CITY OF ALBUQUERQUE

**Re: Santa Fe Federal Credit Union, 7101 Jefferson Street NE, Grading and
Drainage Plan, Engineer's Stamp dated 06-04-2013 (D-17/D017)**

Based upon the information provided in your submittal received 06-06-13, the above referenced plan cannot be approved for Building Permit until the following comments are addressed:

SHEET NUMBER
C.1

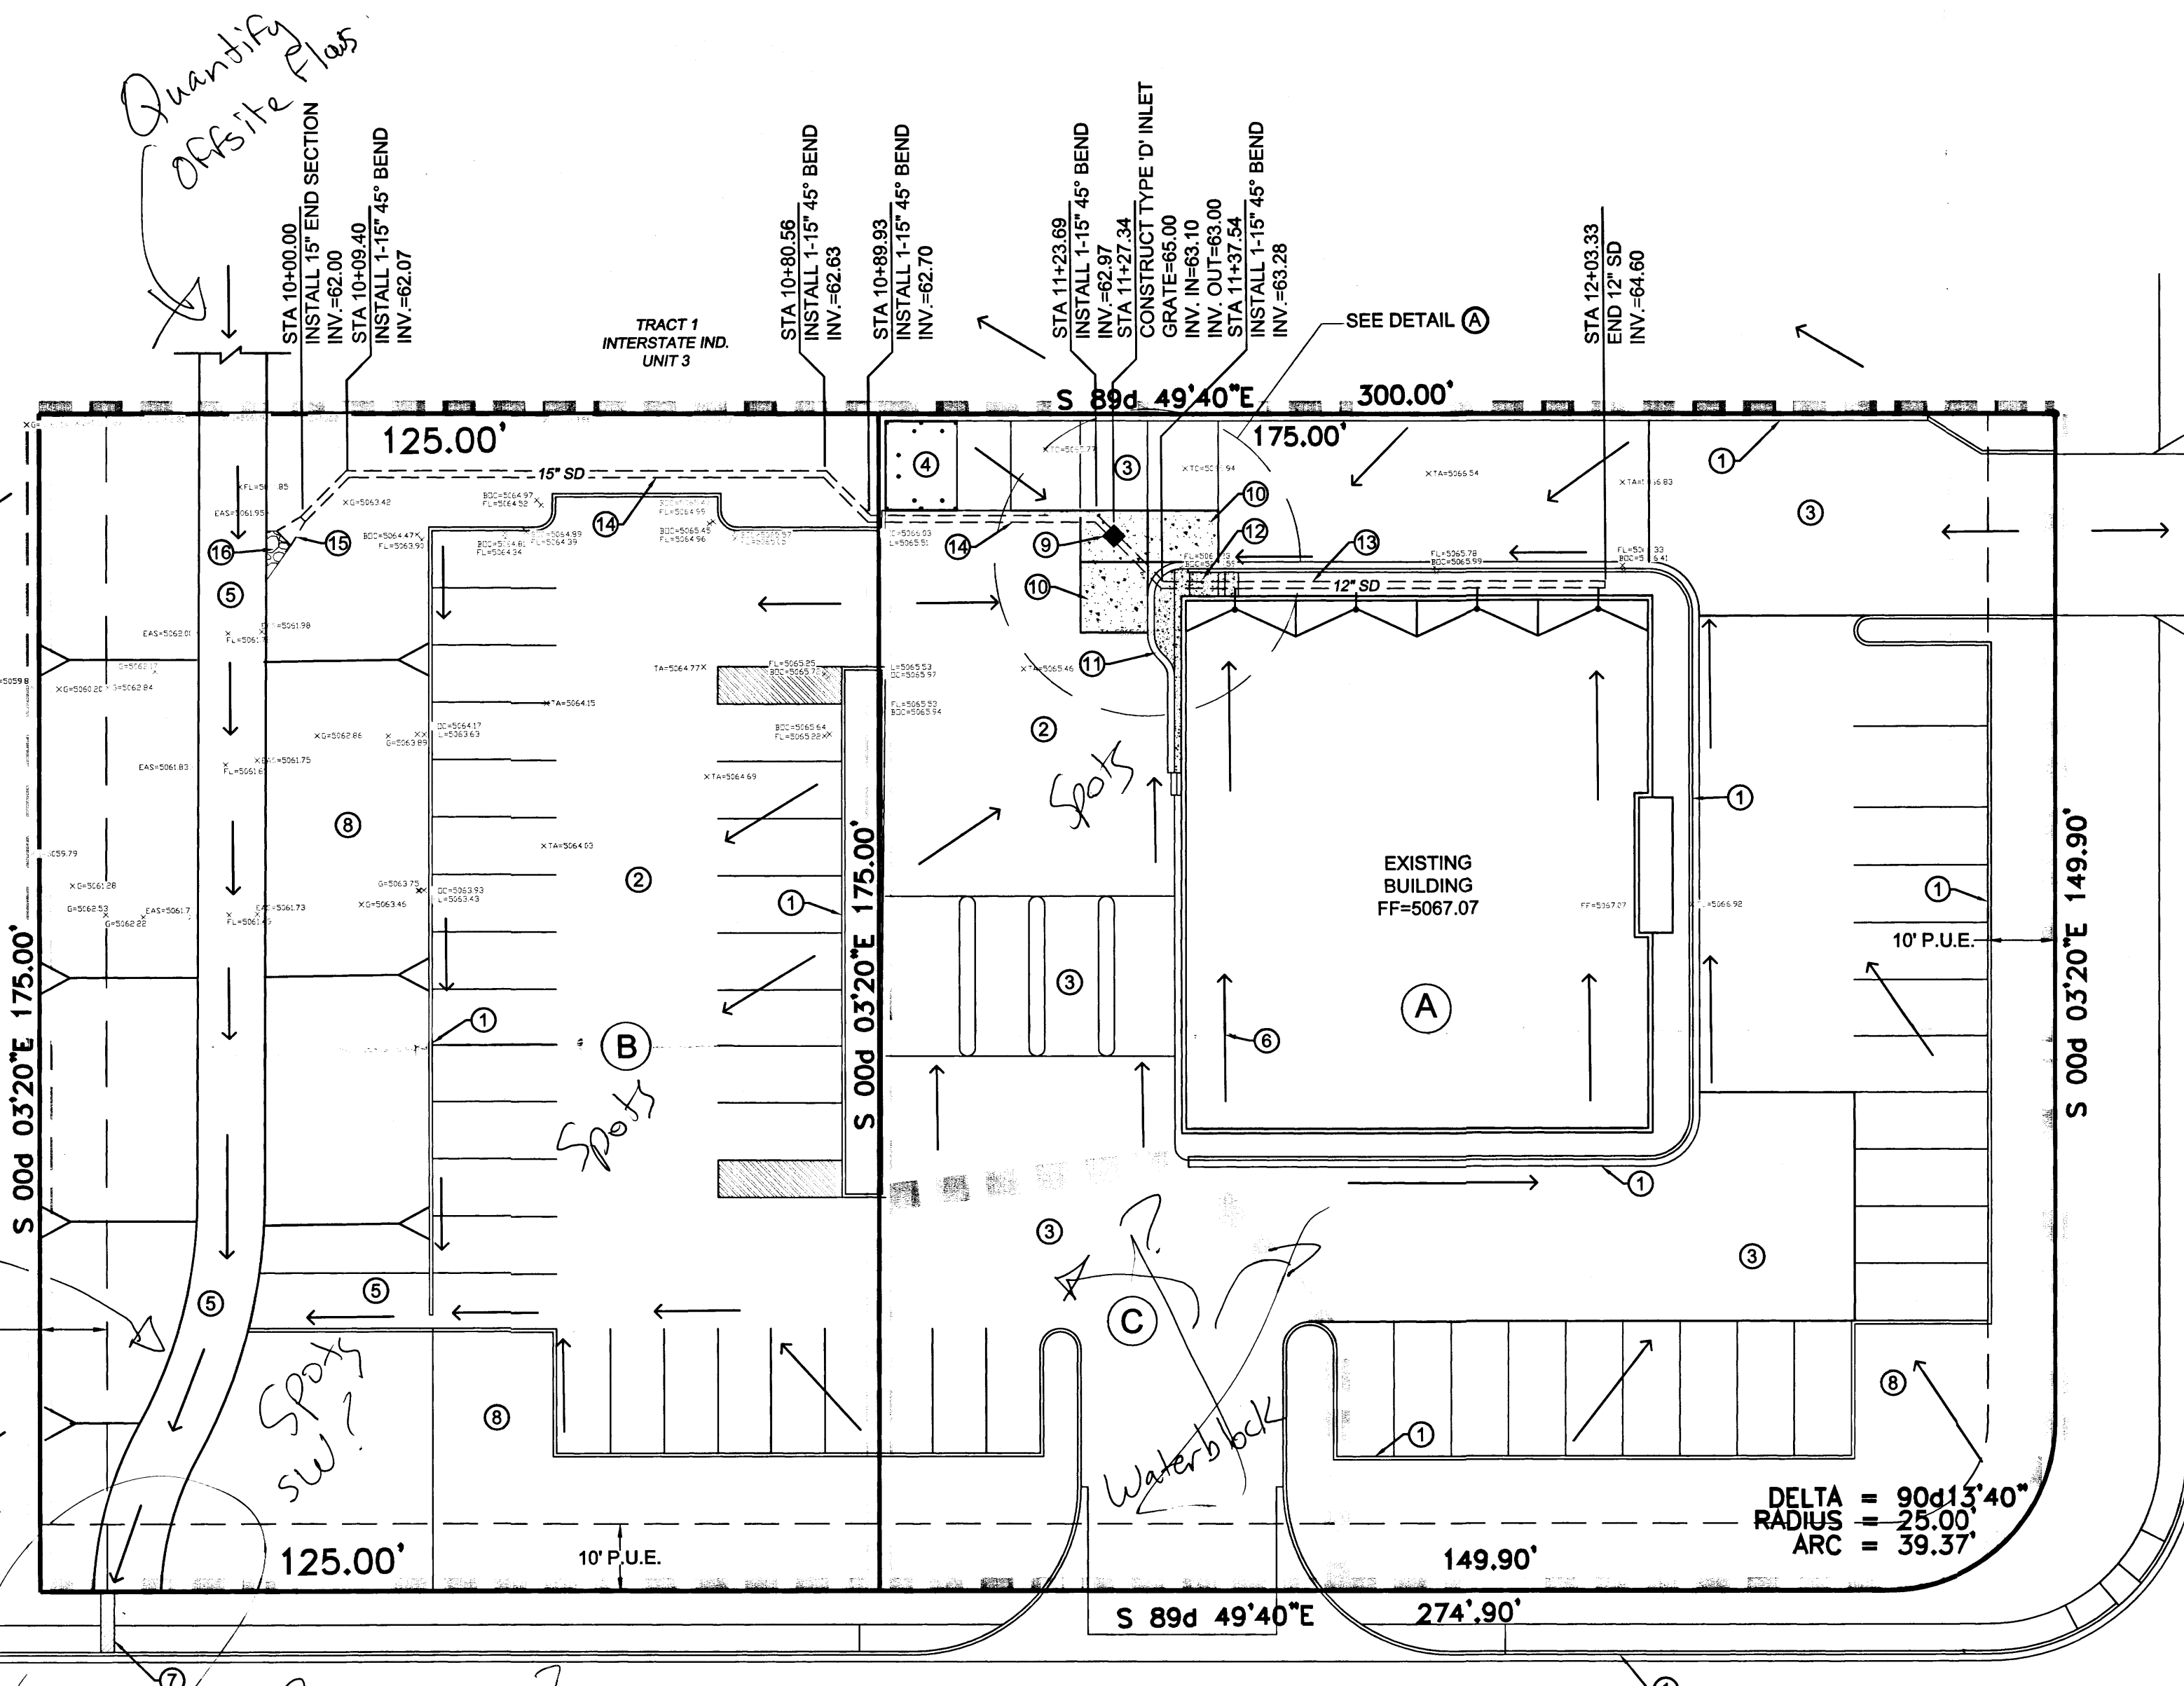
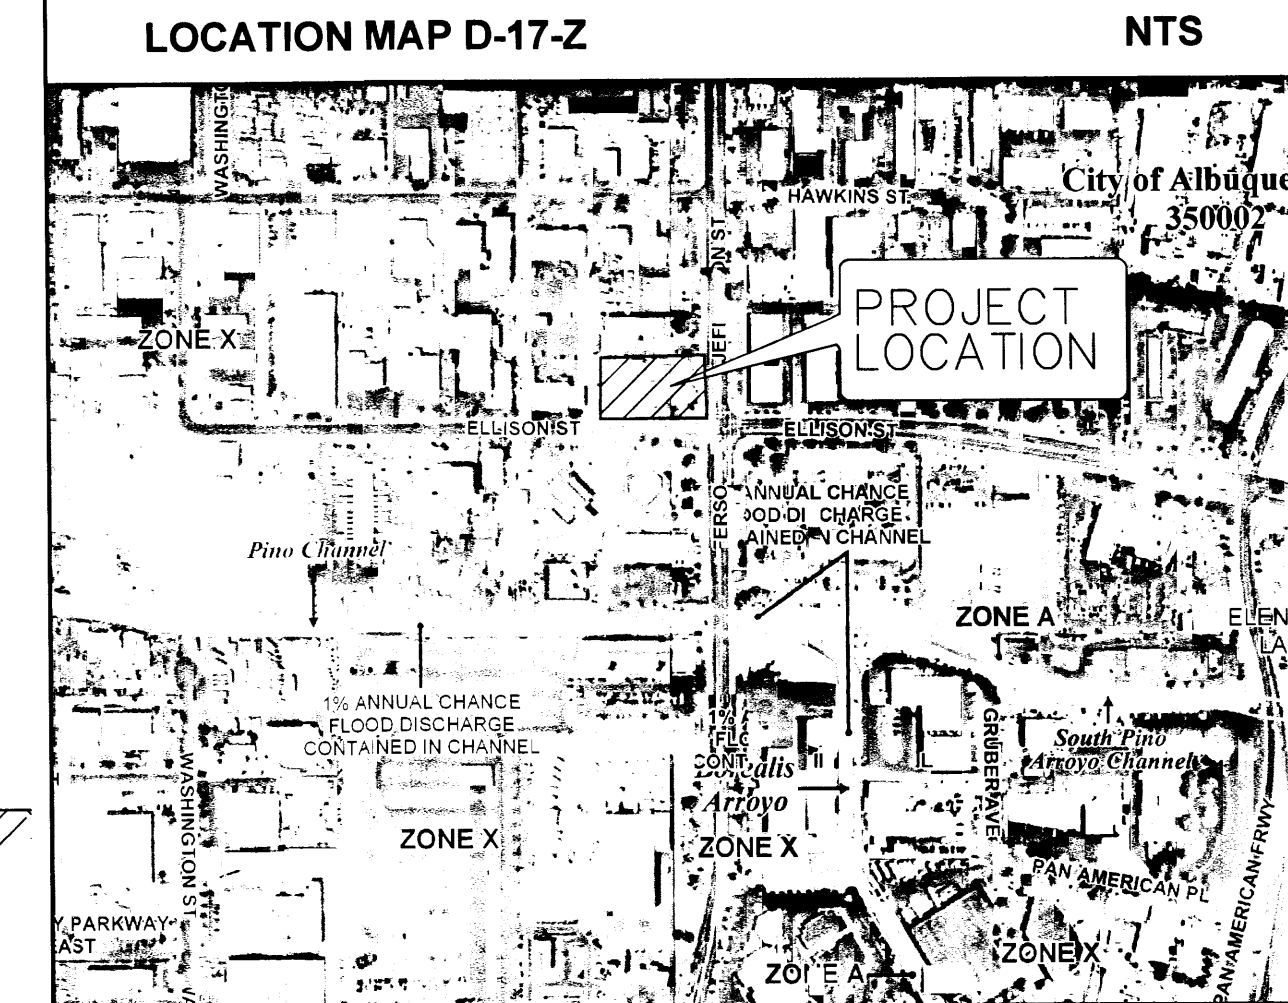
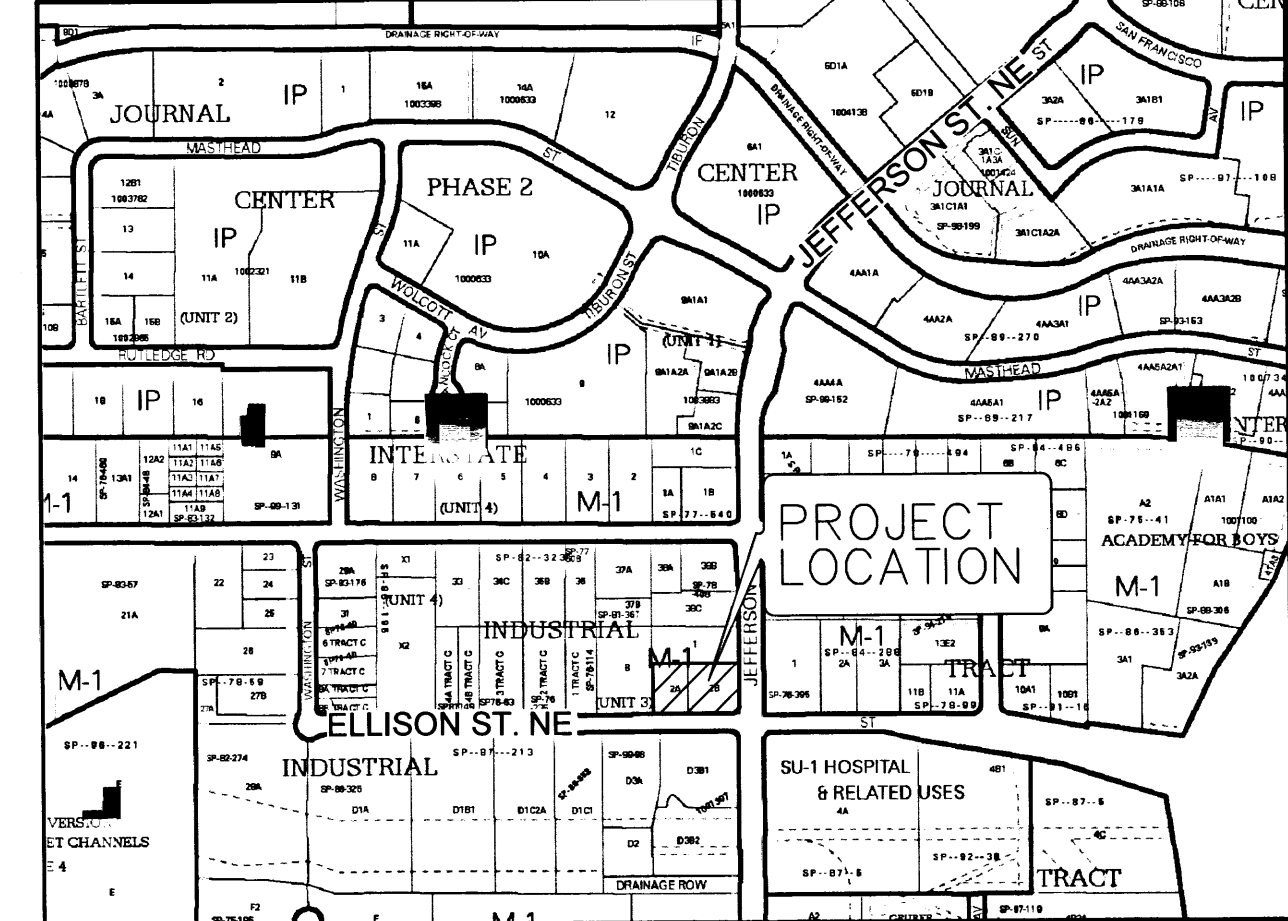
- Please quantify the offsite flows from the parking lot to the north of your project and include these flows in the drainage calculations for the existing sidewalk culvert; if over capacity address how these flows will be accommodated.
- Add a note to extend the culvert and culvert plate two feet back from the property line and to tack weld the bolts to the steel plate.
- Clarify if the existing swale is completely asphalt lined. Satellite imagery shows a significant amount of sediment in this channel.
- If the sidewalk culvert is altered please provide both an invert elevation and flowline elevations within Ellison Street.
